Planning application 3/2026/0082

91 Berry Lane, Longridge

I have been notified of this application to change the use of the premises, 
 into a “Drinking Establishment” proposed to be open from lunchtime to late evening every day.

91, Berry Lane, Longridge, Lancashire, PR3 3WH

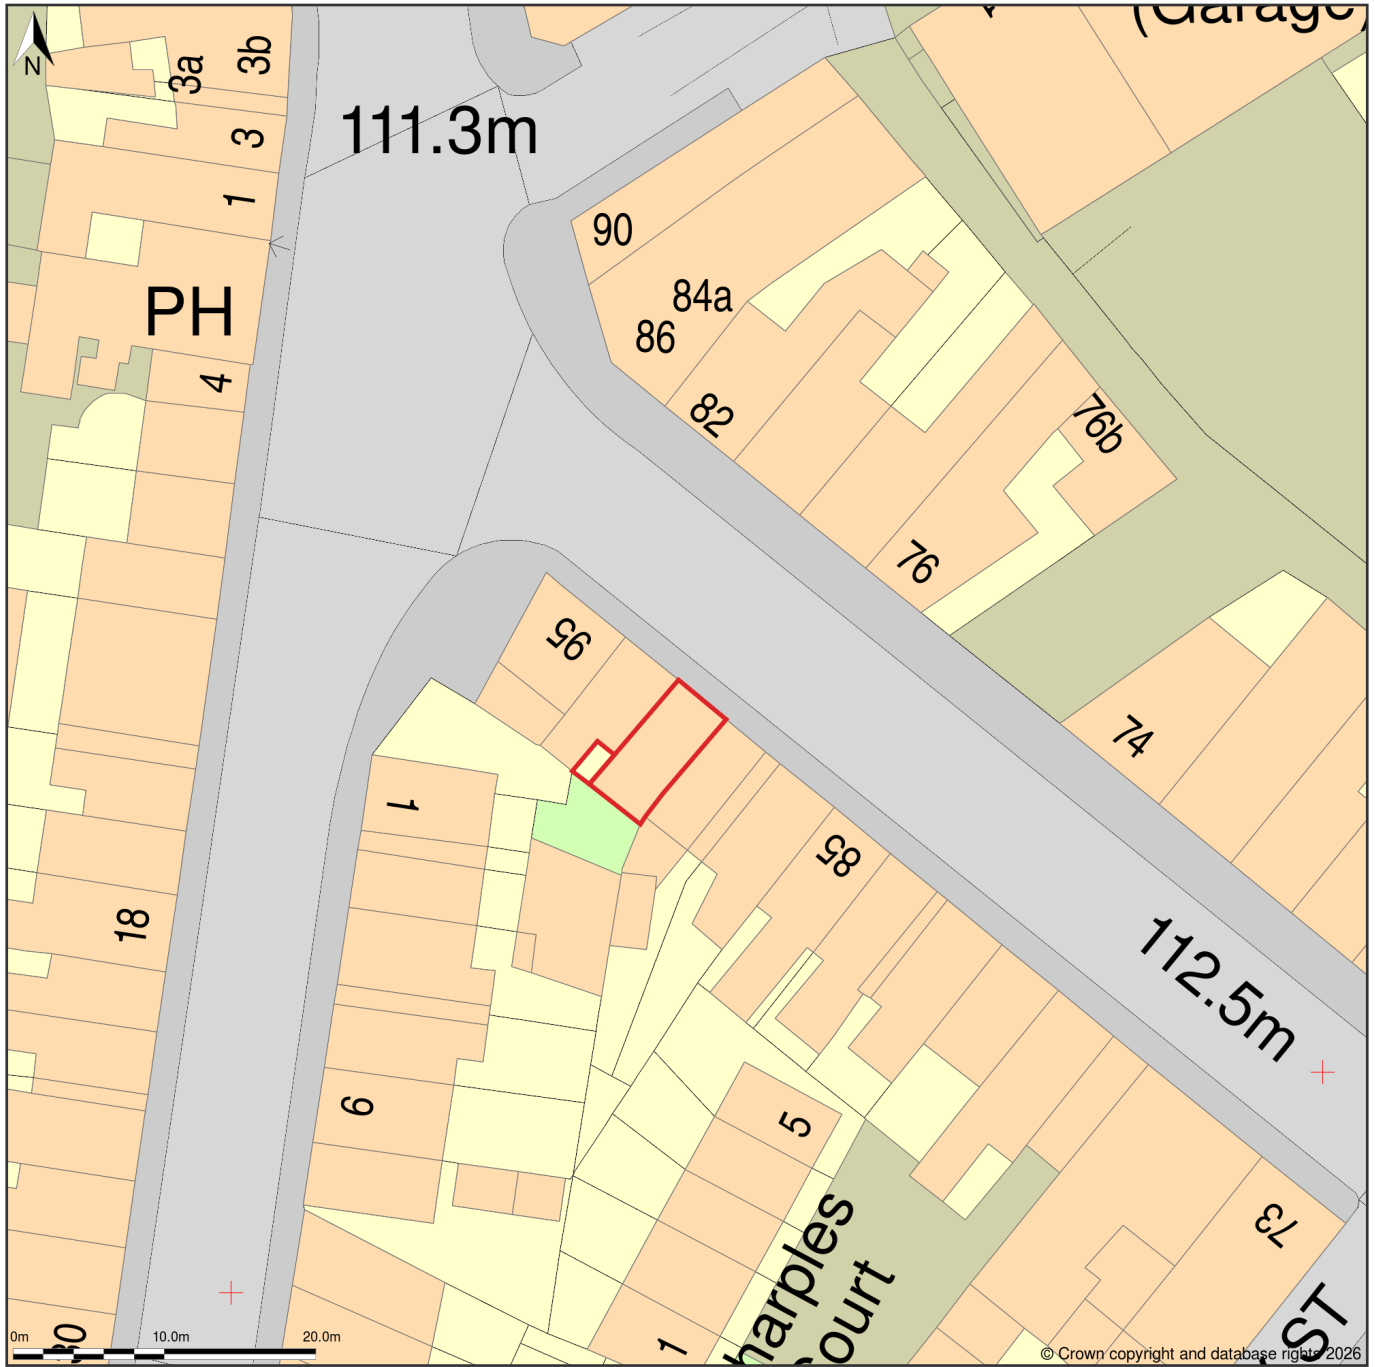
As can be seen from the plan of the site the property forms part of a row of terraced properties.

In addition to the building of no 91 it has a very small rear yard which I doubt adequate to store the waste I think might come from a “drinking establishment” of empty bottles and associated packaging.

There is no access to this small rear yard except through the premises of 91.
